Date: 22-Dec-2022
Our Ref: 2022/93522

**TOWN AND COUNTRY PLANNING ACT 1990
TOWN AND COUNTRY PLANNING (GENERAL PERMITTED DEVELOPMENT)
(ENGLAND) ORDER 2015 (as amended), SCHEDULE 2, PART 3, PART MA
NOTIFICATION OF PROPOSED CHANGE OF USE CLASS MA – COMMERCIAL,
BUSINESS AND SERVICE USES TO DWELLINGHOUSES
APPLICATION NUMBER: 2022/93522
AT: first floor, 27, Market Street, Milnsbridge, Huddersfield, HD3 4ND**

Prior approval of a proposed change of use of a building from commercial, business and service uses to dwellinghouses

Drawing no.
 102

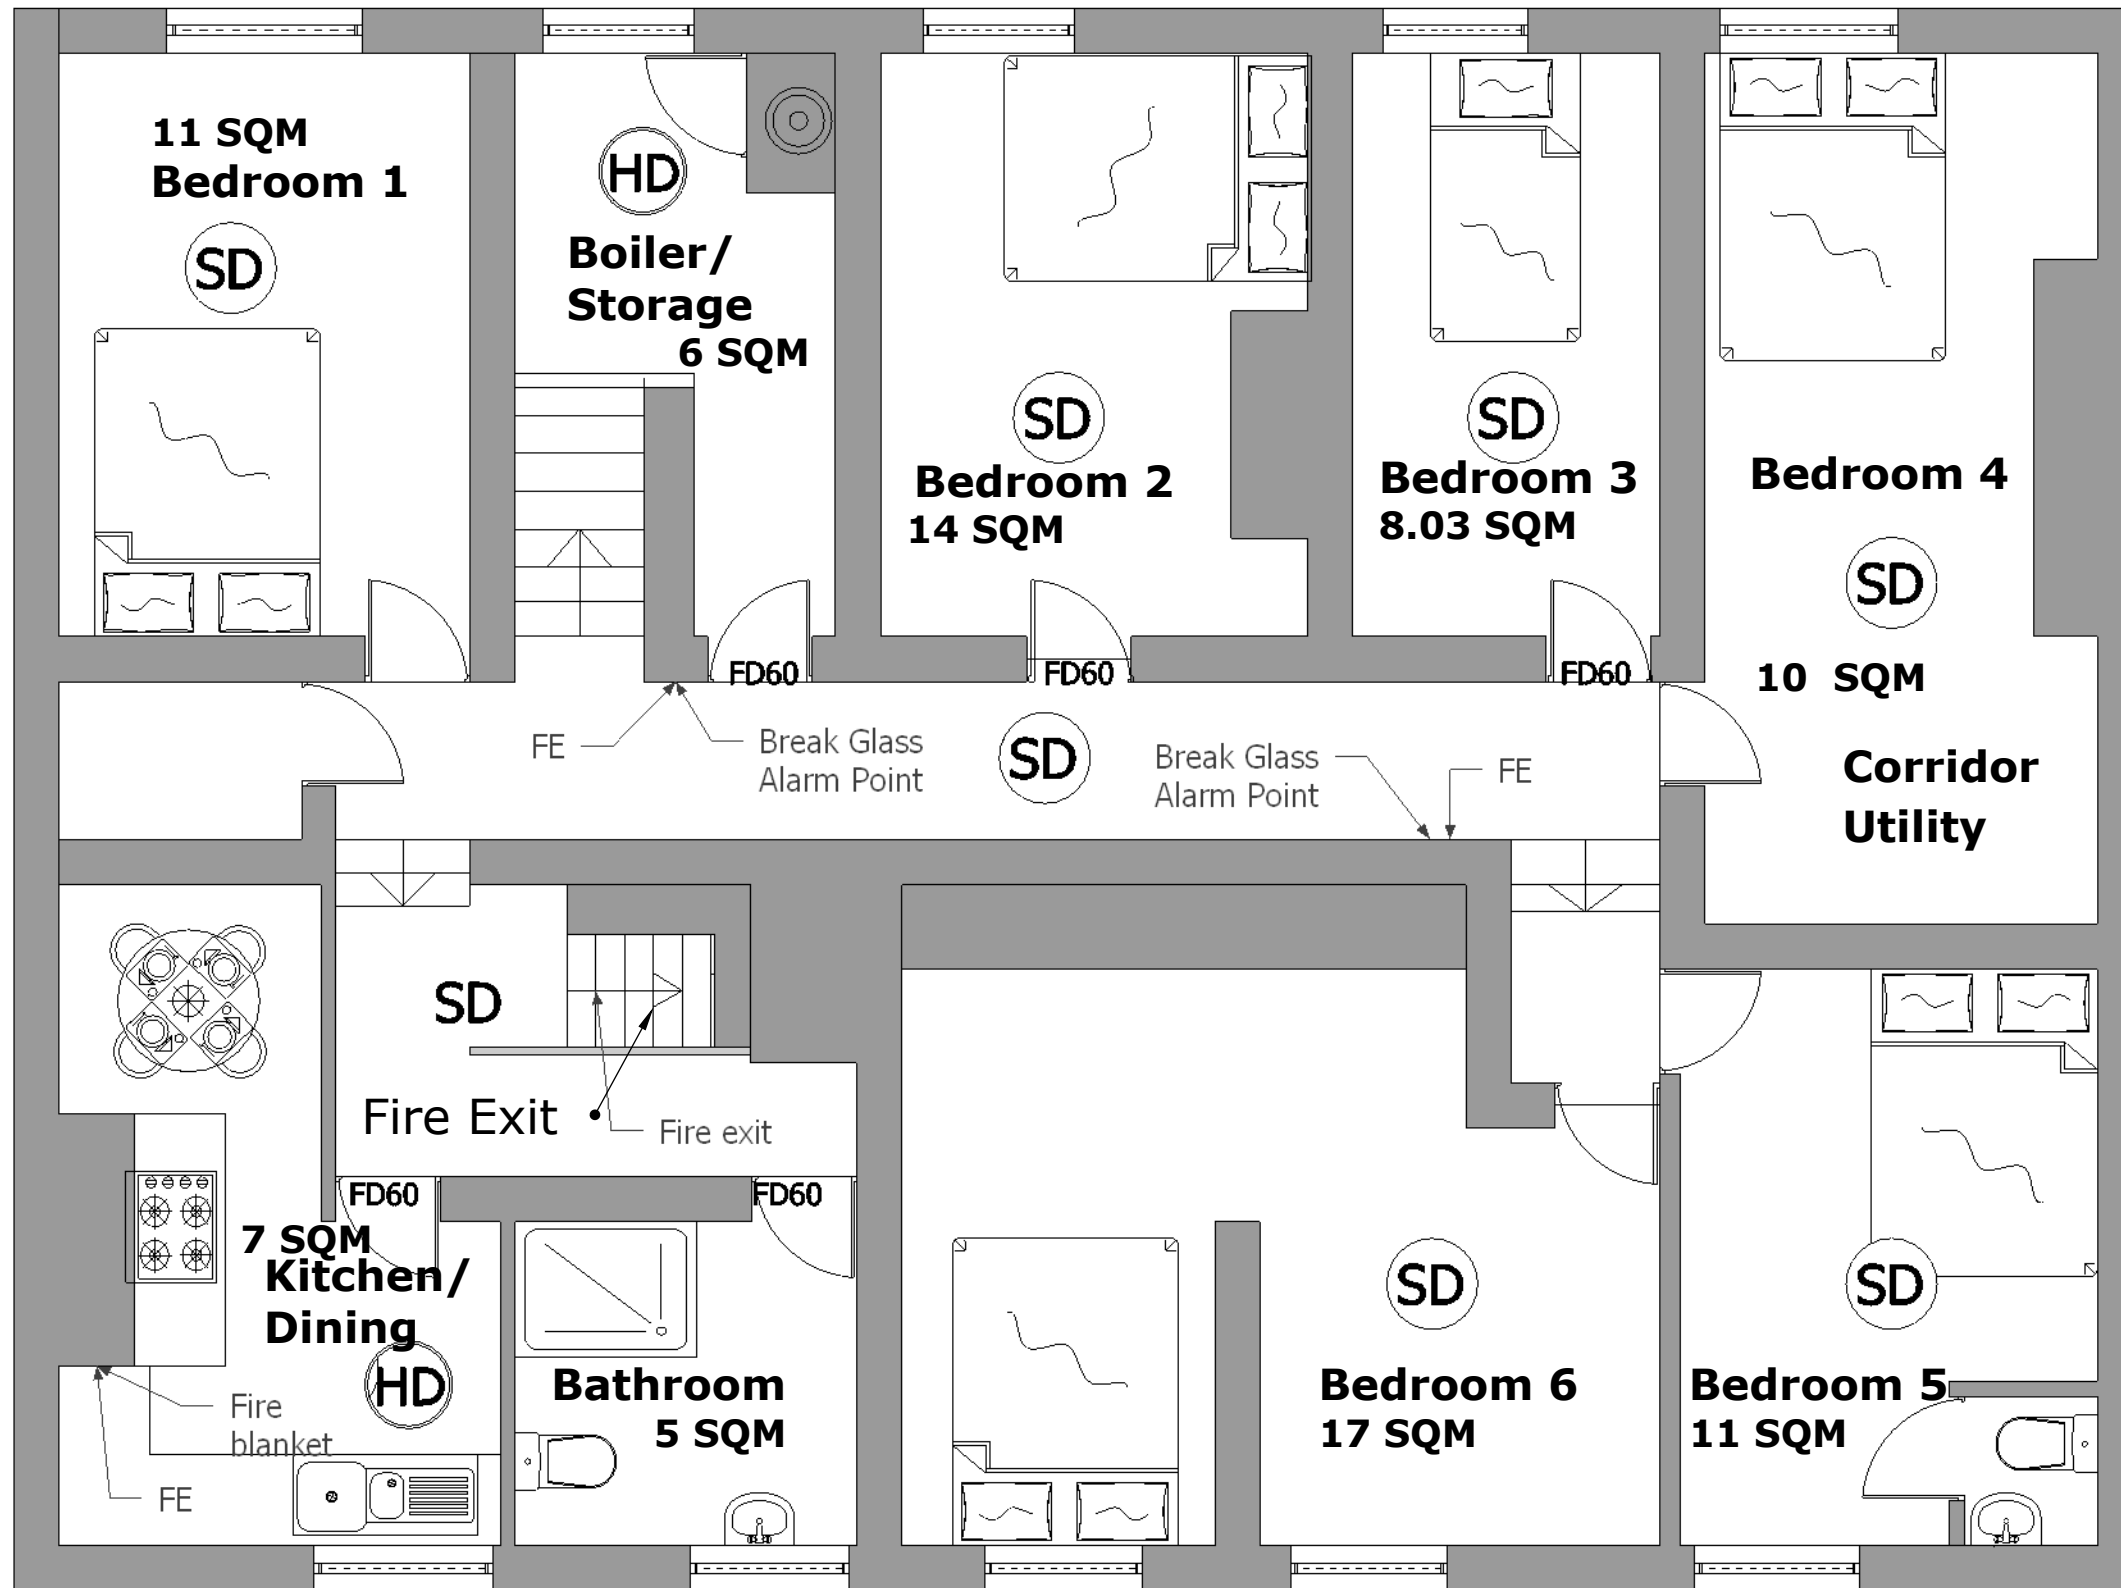
It is considered the internal gross floor space of the dwellinghouse does not meet the space standards for the 11 bed spaces proposed.

The submitted information also indicates that 1 no. single bedroom would be created which would meet the standards (bedroom 3) and 5 no. double bedrooms are proposed of which 3 of the bedrooms (bedrooms 1, 4 and 5) which would fail to meet the required space standards.
